From: leona sampson [REDACTED]
Sent: 21 February 2020 13:01
To: Planning <Planning@arun.gov.uk>
Subject: TPO

I write in response of the TPO AW/19/20/T at 6 Cedar close to amend the given

REF1

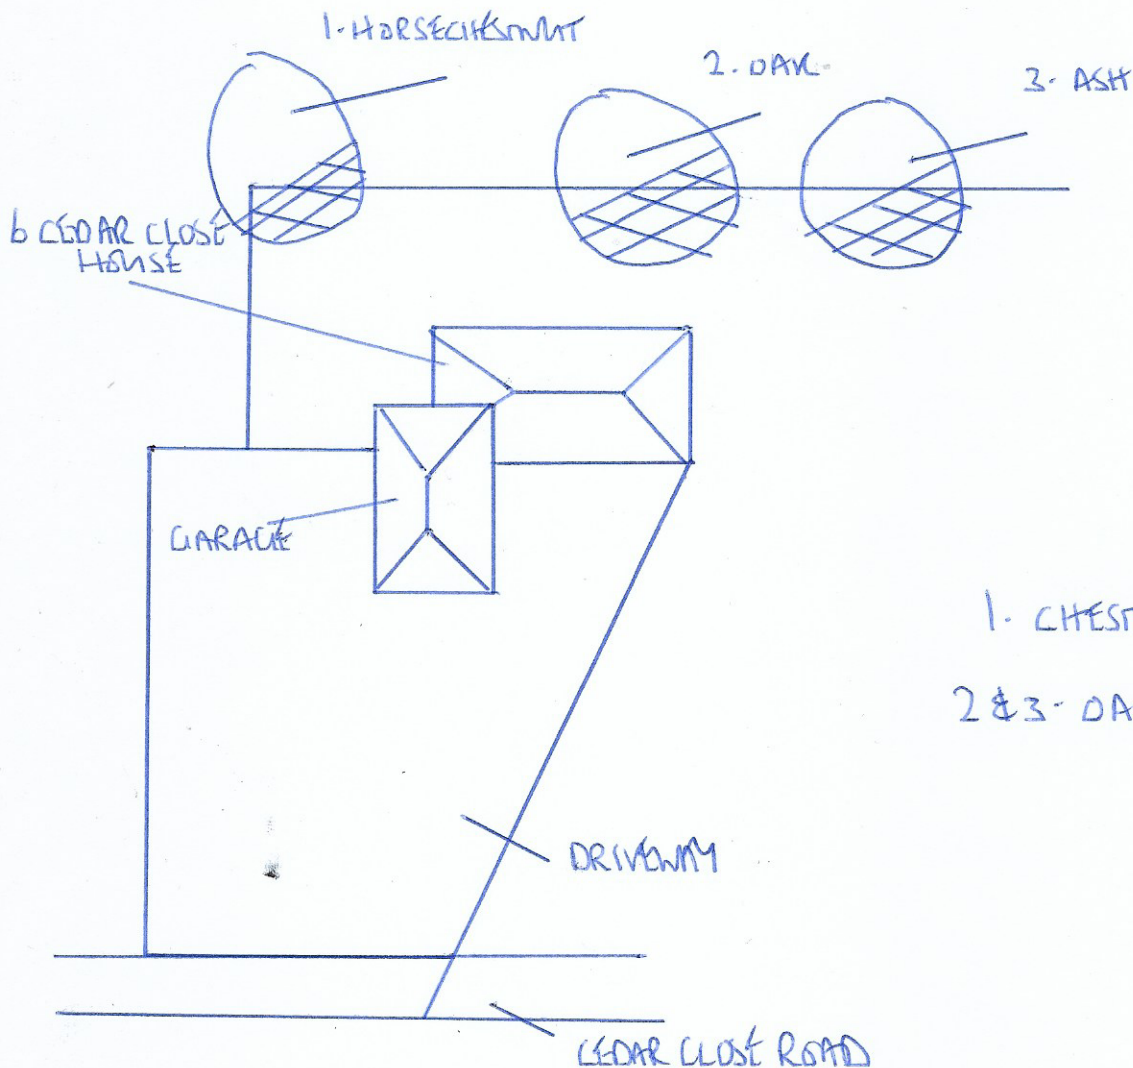
1. To reduce the over hang on No1 Oak tree by 2meters leaving 9meters after pruning.
2. To reduce the over hang to No1 Horsechestnut by 7meters to leave 1meter after pruning, there is evidence of weaknesses in this over hang.
3. To reduce the height on No1 Ash by 2meters and leaving 6meters after pruning and to reduce the laterals by 2meters leaving 4meters after pruning.
